Local Impact Report for HORNSEA PROJECT THREE OFFSHORE WIND FARM BY South Norfolk Council

Our reference 20010599

The LIR relates only to the onshore elements and identifies the most relevant policies and the main issues the Council has concerns over.

Figure 1.1: Onshore HVDC converter/HVAC substation – heritage viewpoint locations.

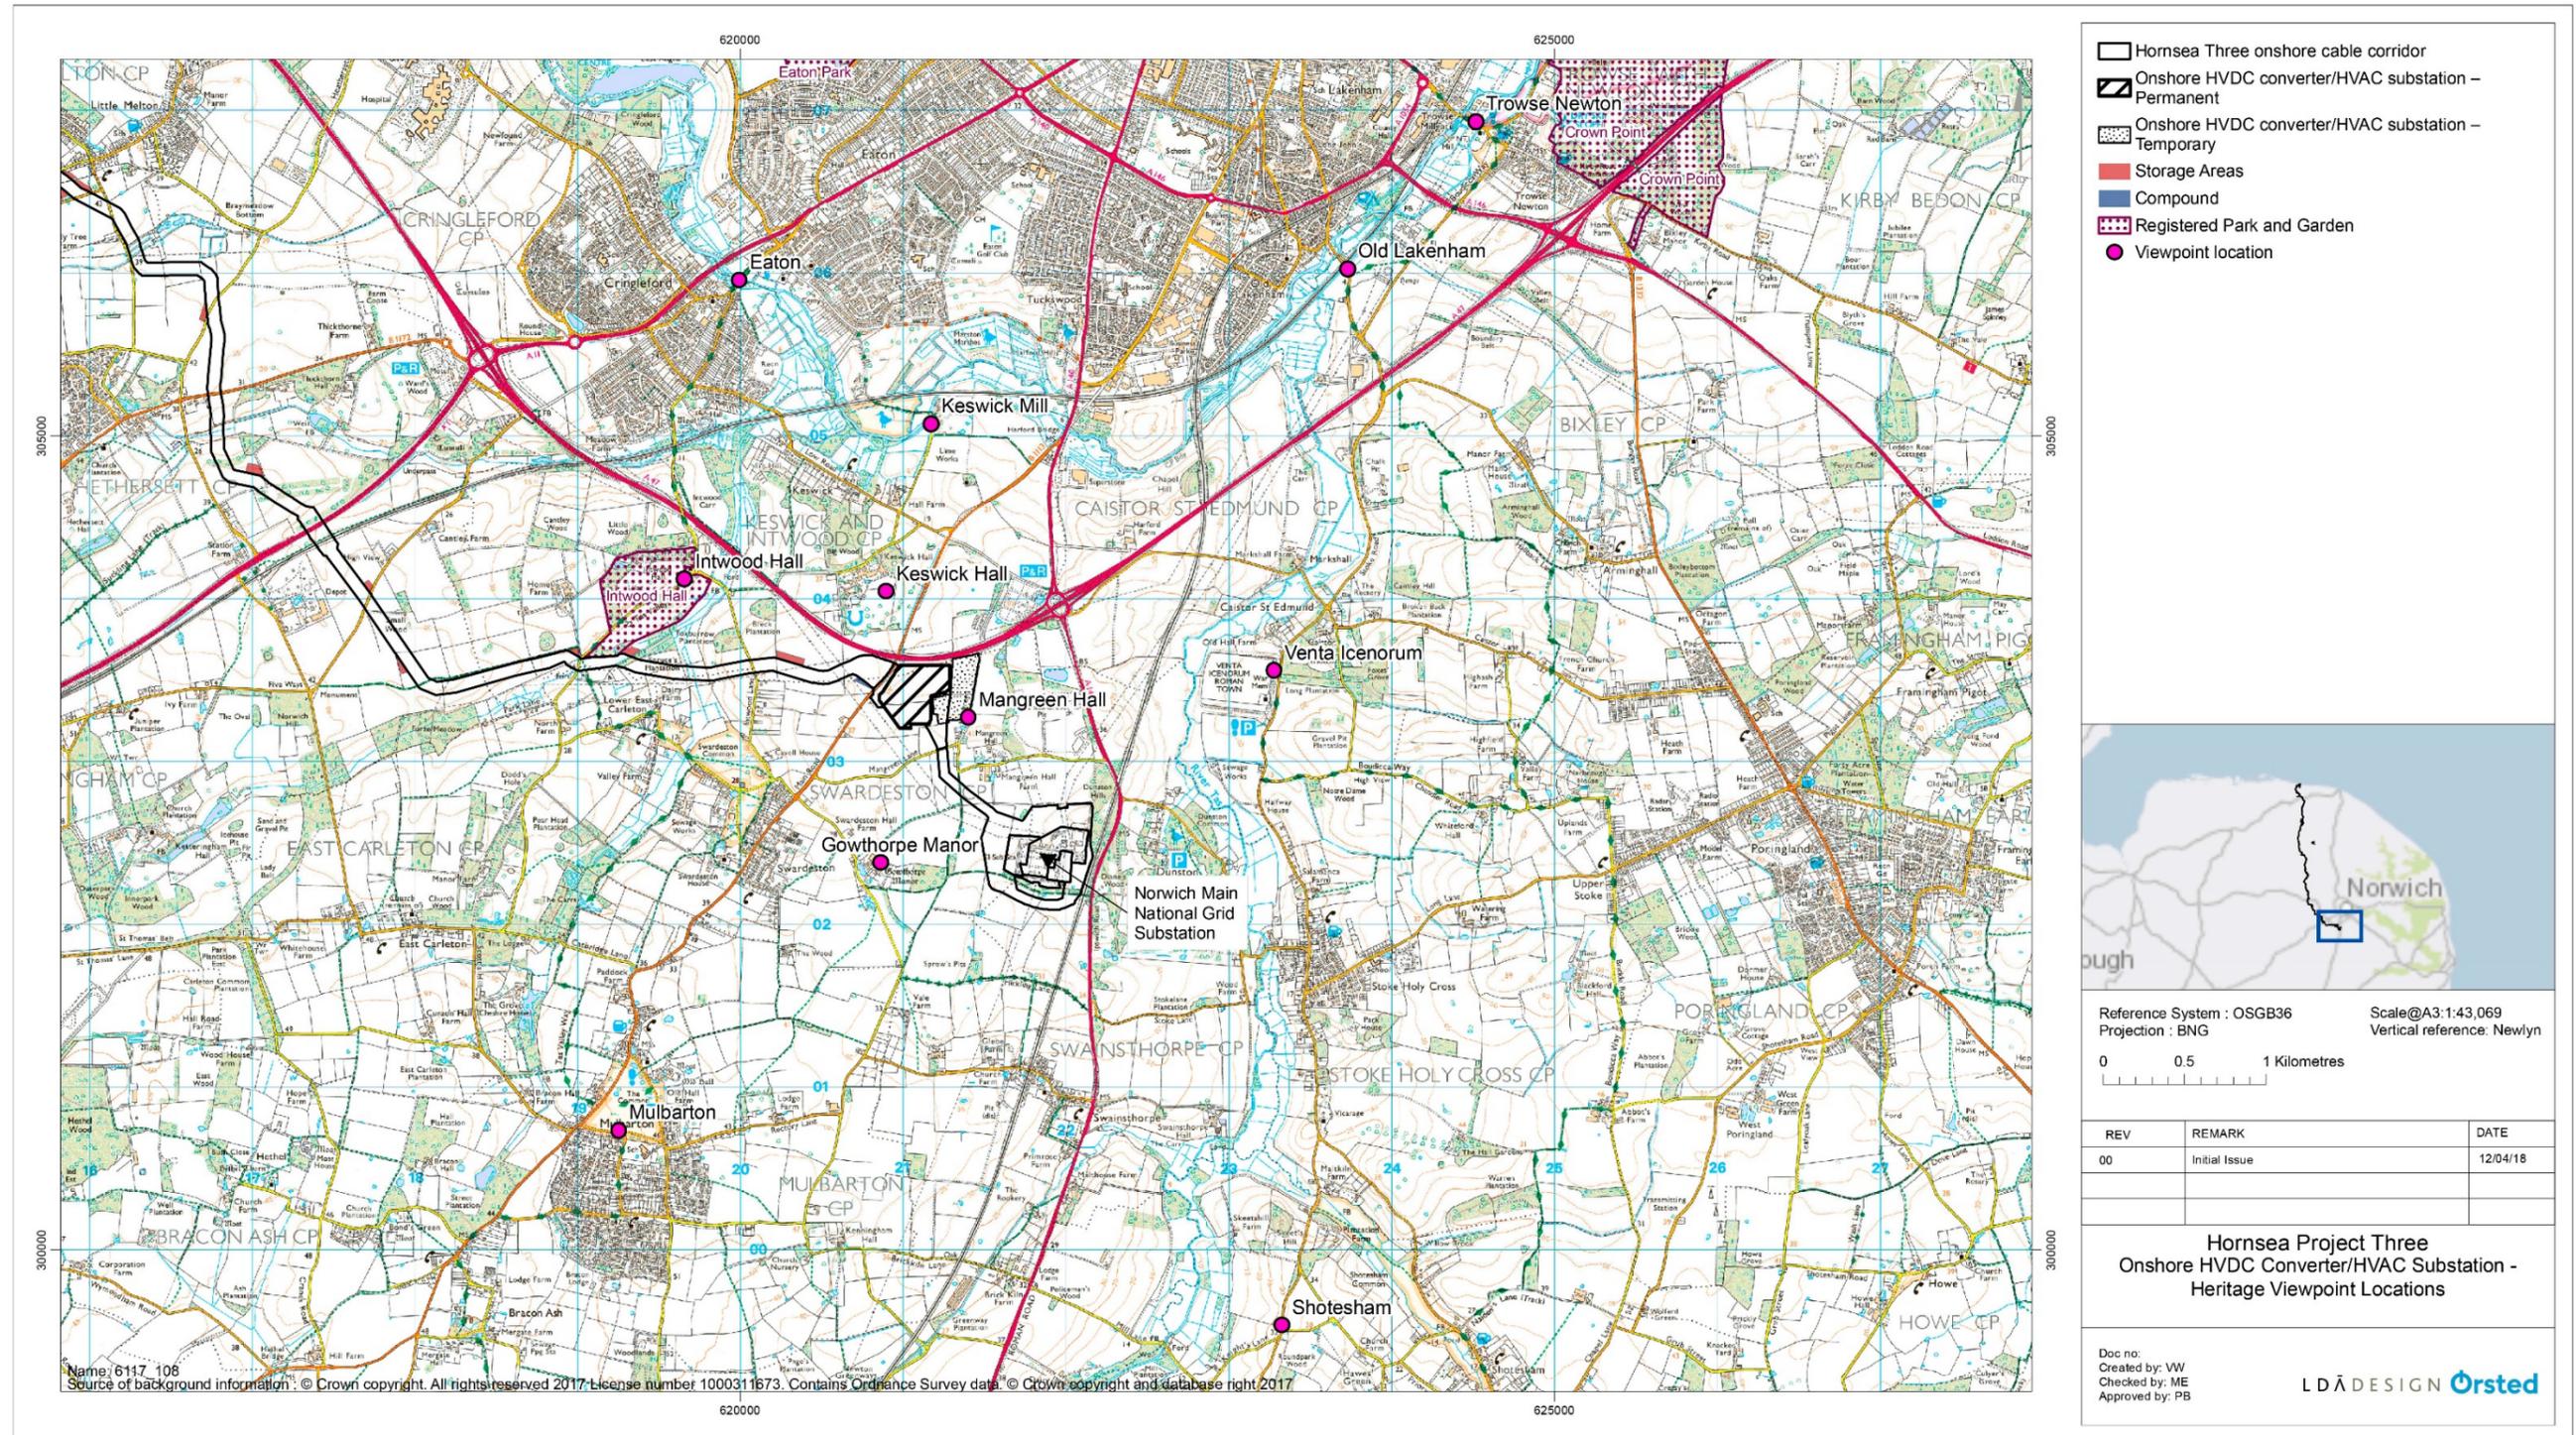
In terms of Keswick Hall as a listed building the Council would agree with the sensitivity being **medium**, but would suggest that the magnitude of impact on its setting would be deemed to be **moderate**. The statement states that it would be Minor, since there would be no physical impact on the designated asset. However, views from the listed building across the parkland with a backdrop of open countryside are important to appreciating the original design of the house as being a country house within a designed parkland within open countryside. The new substation would be a large bulky and alien feature within this setting and the Council would therefore consider that according to table 5.11 the impact would involve “change within the setting leading to some loss of significance of the asset”

and can therefore result in a moderate magnitude of impact, and it would be the case here. The resulting impact would therefore be **moderate adverse**.

The EIA states that the impact on Keswick Hall would not be considered significant in terms of an EIA assessment, however the Council consider that the adverse impact on the hall is of significance in determining the application, as it would also be in considering the setting of the historic park and garden. The historic building visualisations clearly show that a 25m high building will be very visible looking south across the parkland from the rear of the house and this would have a significant and harmful impact on the setting of the grade II listed Hall and the setting of the parkland. Taking into consideration paras 129, 132 and 134 of the NPPF and policy DM 4.10 of the Local Plan, this would be considered less than substantial harm since the assets are not directly physically affected, however, section 66 (1) of the Planning (listed building and conservation areas) Act 1990 would require that considerable importance and weight should still be accorded to the "desirability of preserving... the setting" of listed buildings when weighing this factor in the balance. Also, para 135 of the NPPF requires that "The effect of an application on the significance of a non-designated heritage asset should be taken into account in determining the application. In weighing applications that affect directly or indirectly non-designated heritage assets, a balanced judgement will be required having regard to the scale of any harm or loss and the significance of the heritage asset."

In view of the above it is considered that the impact of the development on both the setting of Keswick Hall and the setting of the historic parkland should be considered to be a greater level of impact and of more significance in the EIA than currently attributed. Some of the degree of harm can be mitigated against through various measures such as having a building which is lower height, which would result in noticeably less harm if below or closer to the tree line rather than rising above it. Other mitigating measures can include further tree planting and a recessive colour for the building, which could for example be darker colours at lower levels where seen in the backdrop and below the treeline, and lighter colours where the building is seen in views above the treeline.
